**RFI**

To: Jordan & Skala Engineers, Inc. RFI #: 3  
14240 Midway Road, Suite 350 Date: 11/22/2011  
Dallas, TX 75244 Job: EB-02 Keller Springs Lofts  
Ph: 469/385-1616 Fax: 469/385-1615 Phone:

Subject: RFI #3 8" sanitary connection

DATE: OCTOBER 27, 2011
 DESIGN: KHA
 DRAWN: KHA
 CHECKED: KHA
 KHA NO.: 064362003
 CITY NO.:
 SHEET
C10

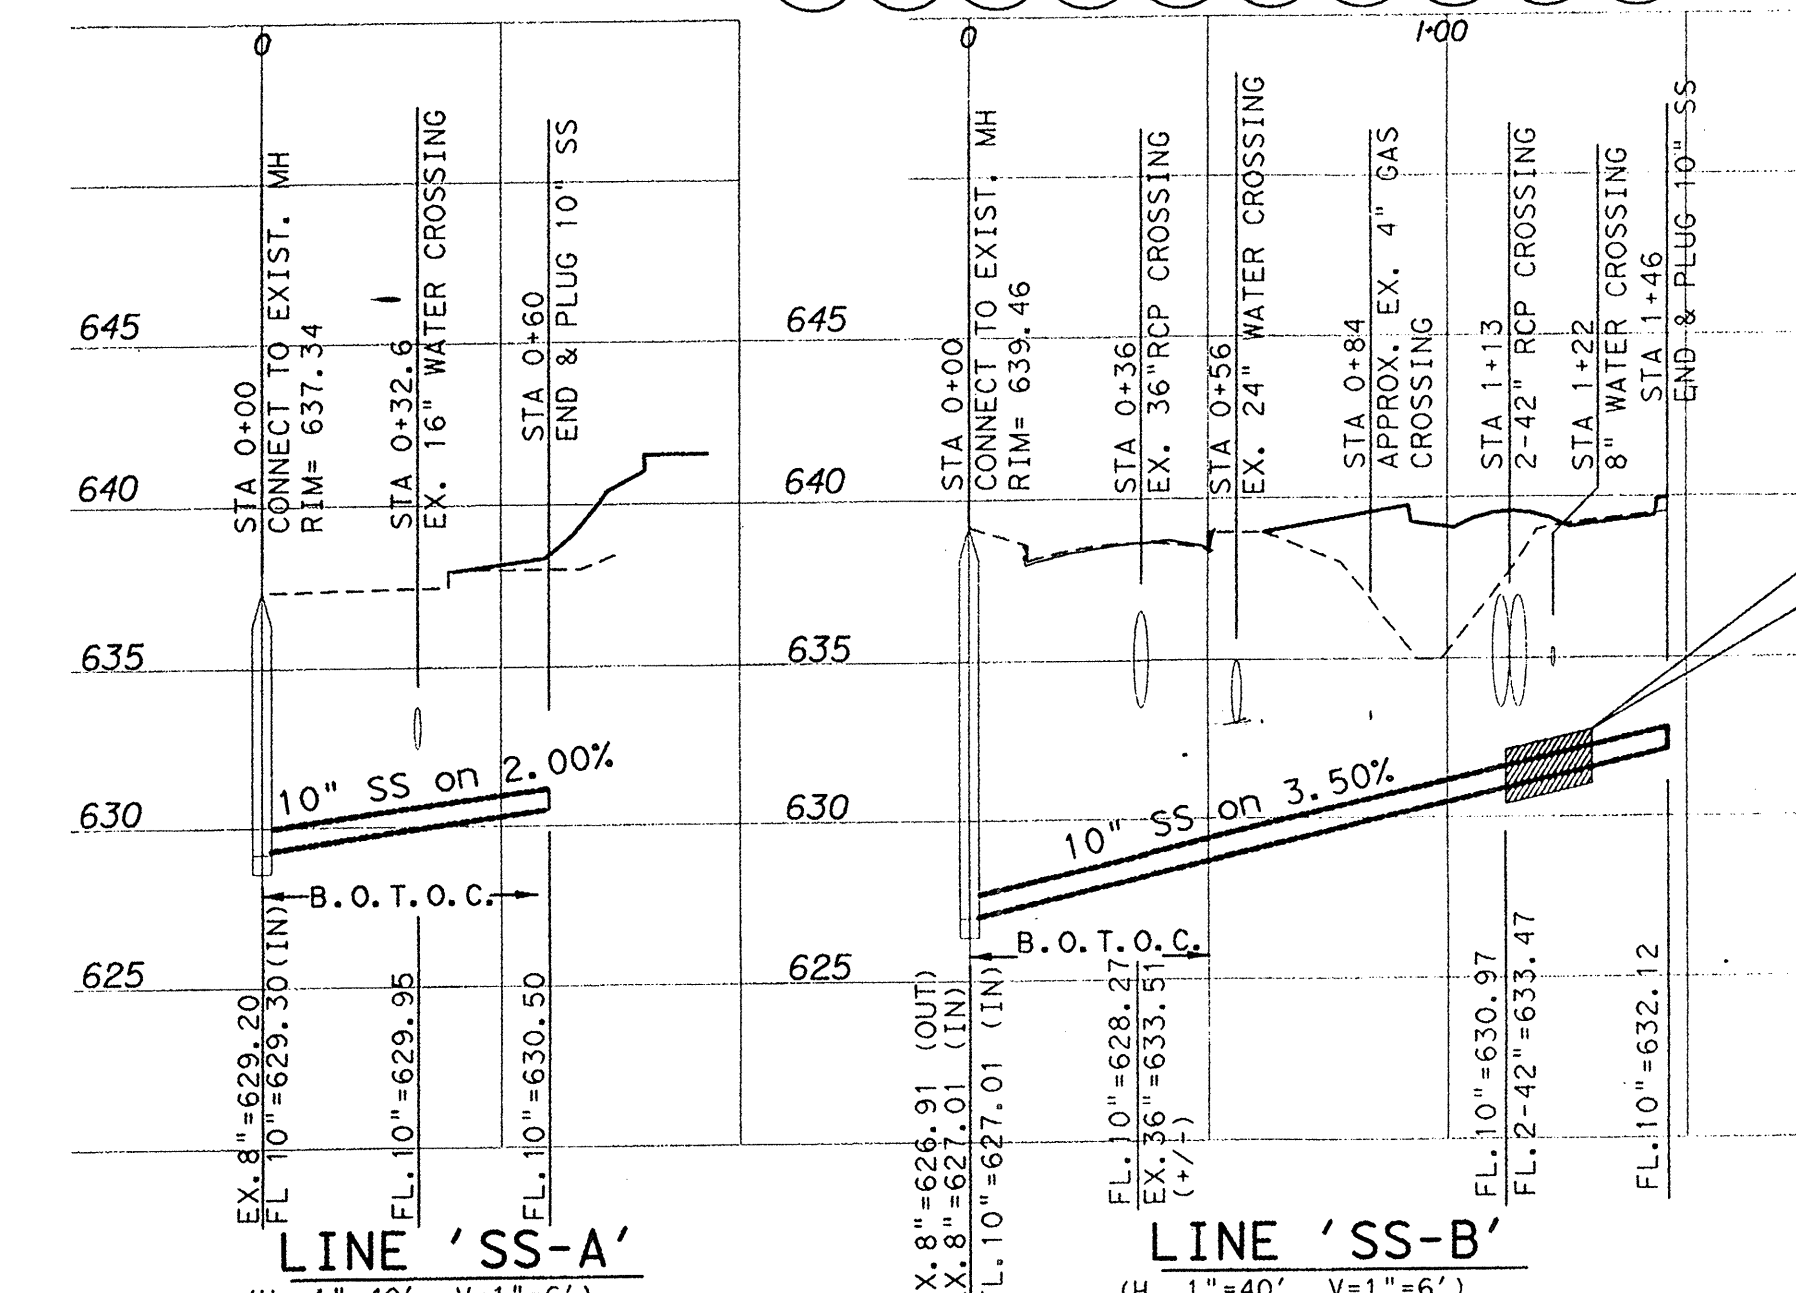
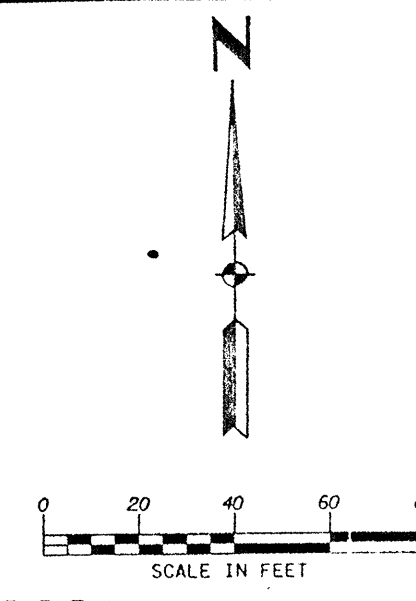
Request: Date Required: 11/28/2011  
We potholed for the sanitary @ line "SS-B" and found an 8" stub out from the existing manhole to 12' back of curb on the south side of Keller Springs. We also shot the top of the existing 10" water line and found it to be 631.39; this means the bottom of the 10" is 630.88. The plans show a FL = 629.95 for the 10" line at this point, that is more than the .73 we have and not considering 1' separation of utilities, so we have several things to look at.  
First, can we use the existing 8" and is there clearance between utilities.  
Second, if we have to put the 10" will we have enough slope and clearance. It appears the existing 8" is in the exact line location you have on your plans (North to South).  
Third, the plans show existing 10" lines coming into this manhole from the east and leaving it to the north. My utility foreman said he checked those lines and they are 8" not 10".

Response:  
Use the existing 8" wastewater line and add a proposed manhole at the south end. Add a proposed 10" stub out from the proposed manhole to the south. Since we are using the existing 8" wastewater line, there is not a conflict at the 16" water line crossing. Plans were updated to show the existing 8" wastewater lines, as opposed to the 10" wastewater lines that were previously shown.

1  
Revision  
C3, C4 & C10
